## Town and Country Planning Act 1990 (As Amended) Local Highway Authority (LHA) Response

<b>Application Reference</b>	2025/1867/DCO		
<b>Proposal</b>	Consultation on Notice of Application to make a Non Material Change to the Development Consent Order: The Northampton Gateway Rail Freight Interchange Order 2019 S.I 2019 No. 1358 Proposed Amendments – increase in mezzanine floorspace and associated minor amendments to site access roundabout and DCO Requirements.		
<b>Location</b>	Northampton Gateway Rail Freight Interchange Collingtree Road Milton Malsor		
<b>Case Officer</b>	[REDACTED]		
<b>Date Consulted</b>	09/05/2025	<b>Date Sent</b>	06/06/2025

Figure 2 Proposed Mitigation Strategy - Partially Signalised Roundabout

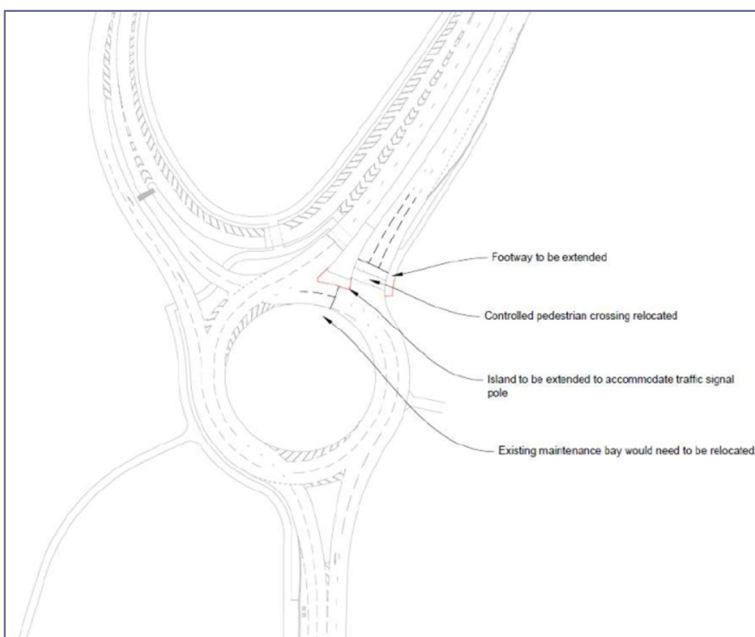
- Due to capacity issues identified an improvement scheme has been put forward at the A508 site access roundabout which involves partial signalisation of the A508 southbound approach arm and circulating carriageway.

- Lack of a controlled pedestrian crossing facilities across the site access arm. (2 lane entry and 2 lane exit). Potential conflict issues that are increased with proposed site intensification.
- Short flare lane feeding into stop line within circulating lane requires sharp and sudden vehicle movement (query design standard). Potential conflict issues.
- The pedestrian crossing on A508 northbound exit arm does not appear to be fully accounted for in the modelling. Hence there are concerns that potential queuing from this stop line may not be fully reported and may block flows. Northbound traffic flows exiting the roundabout may be blocked by traffic queuing at the internal stop line. Similarly northbound traffic stopped at northern exit due to pedestrian crossing may block

- Vehicle swept path analysis suggest some tight movements (e.g. A508 southbound vehicles overlap adjoining circulating lanes). Swept path analysis for 2 lane site arm exit is missing side by side vehicle movement analysis. This appears tight. Potential conflict issues.

Network Layout Diagram

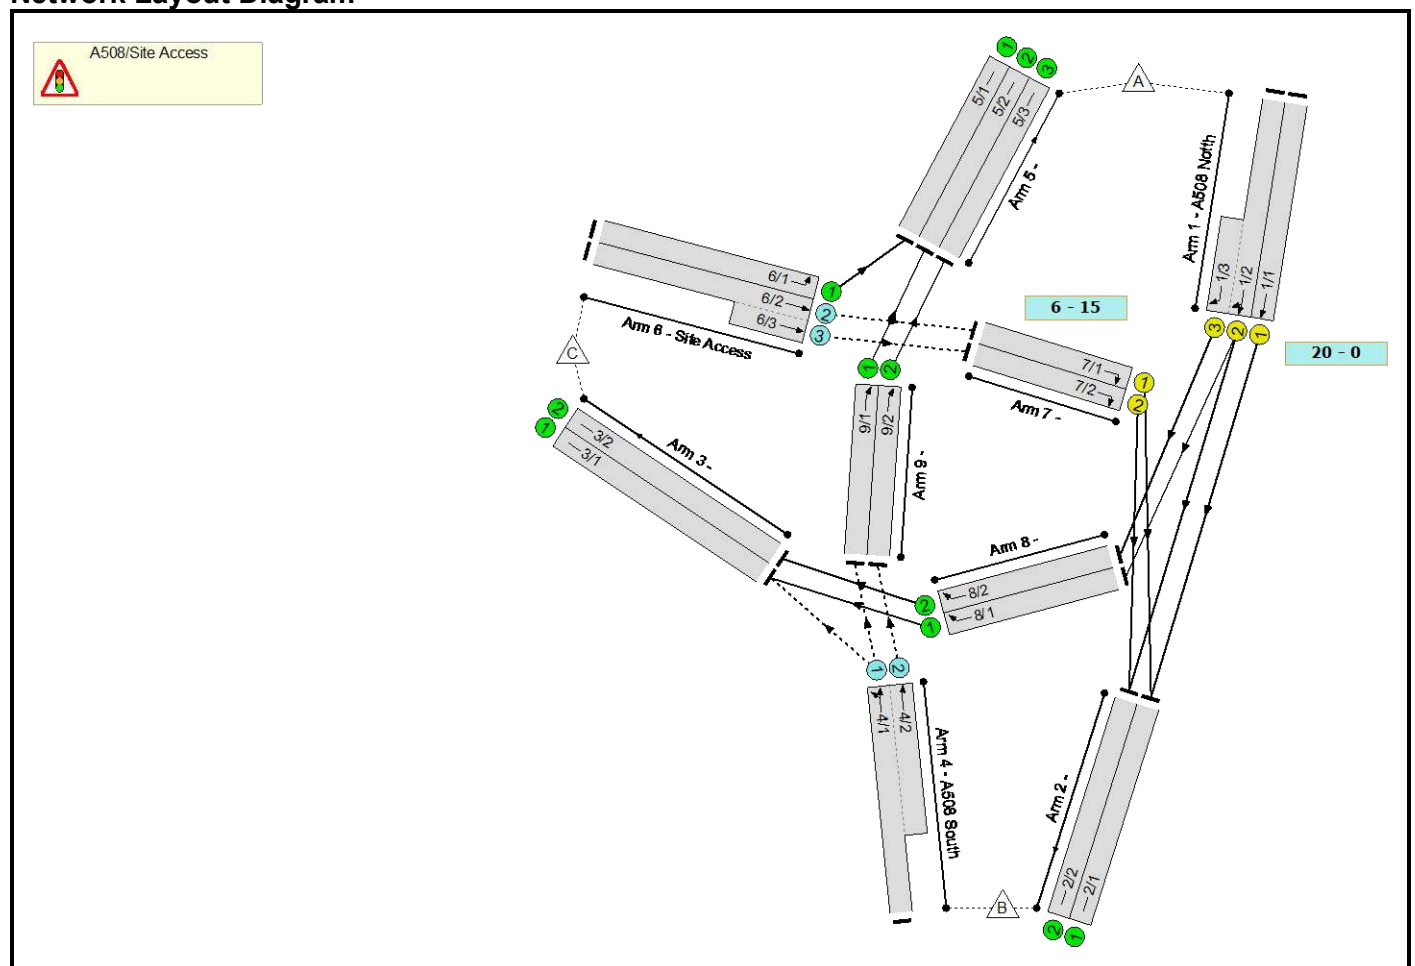
- The suitability of using isolated LinSig model is queried considering the potential interaction of adjoining junctions. The suitability of this approach would be informed by current data / surveys / NSTM and junction model outputs. Though it is noted that the current submission suggests that this would not be an issue.

- The LinSig model output file for the Site Access / A508 roundabout only covers the '2031 with mitigation' weekday AM and PM scenarios. The 'without extension,' 'with extension without mitigation' and 'with extension with mitigation' scenarios should be provided for the AM and PM peak hour periods for all design years. Similar comments apply for the M1 Junction 15 model where only the 'with extension' scenario was presented.

- As noted previously, the LinSig model do not appear to include the pedestrian crossings located on the A508 Northbound exit (as well as on the left turn slip on the site access arm). The peak usage of these crossings is anticipated to coincide with the network peak hour periods (taking account of the bus stop facilities). This would likely impact operation of roundabout and queue lengths resulting in potential conflicts.
